## **Response to Planning Application**

**From:** Arun District Council Greenspace

**Application ref:** R/197/20/OUT

**Location:** Croft Works 52 Mill Lane Rustington BN16 3JN

SITE PLAN 1:250

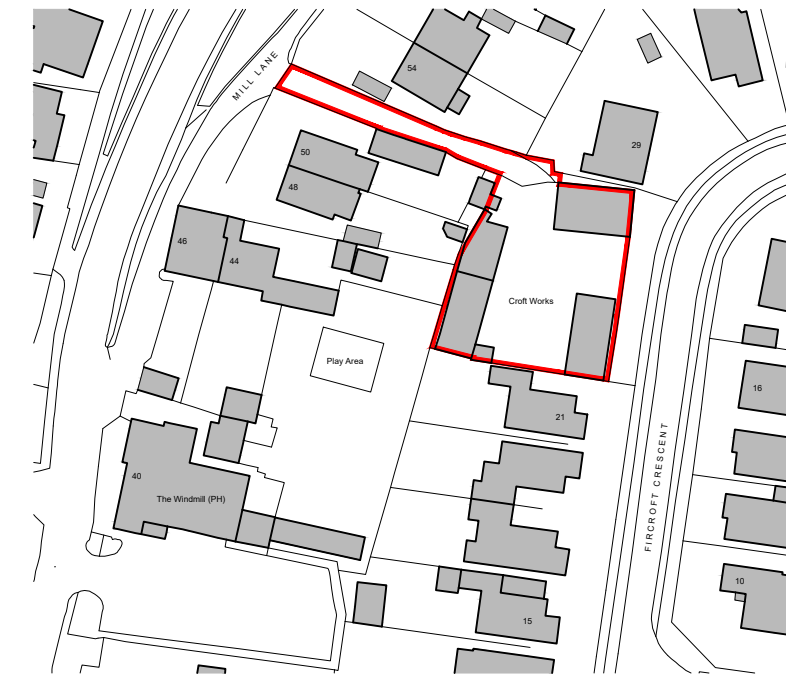
The NPPF para 124/127 relate to good design principles which equally apply to small infill development. The indicative landscape proposals in ECE Architectures Location Plan and Block Plan 011 Dwg has shown indicative planting including screening to southern boundary, which is where potential screening will be required and will have most beneficial impact. This detail will require expanding in the form of a detailed planting plan and specification detailing species choice, actual plant quantities, planting densities and size at time of planting. Detail should also be provided regarding any (limited) existing greenery to be retained which may be fauna and flora beneficial to retain. Offsite existing trees will also need to be protected from root incursion and details re the protection of these to be provided and approved.

Landscape provision to the dwelling frontages and car parking areas will be required. Screening detail to the southern boundary would be recommended adjacent to the boundary of 21 Fircroft Crescent. The outlook adjacent to 29 Fircroft is shown as a planted area and car barn. All proposed planting should be considered and its benefit and gain for biodiversity and habitat explored. Trees specified should be at a size which allow instant impact, but which will establish and mature as the site develops. Planting information would be required in plan form detailing species choice, actual quantities, planting densities and size at time of planting.
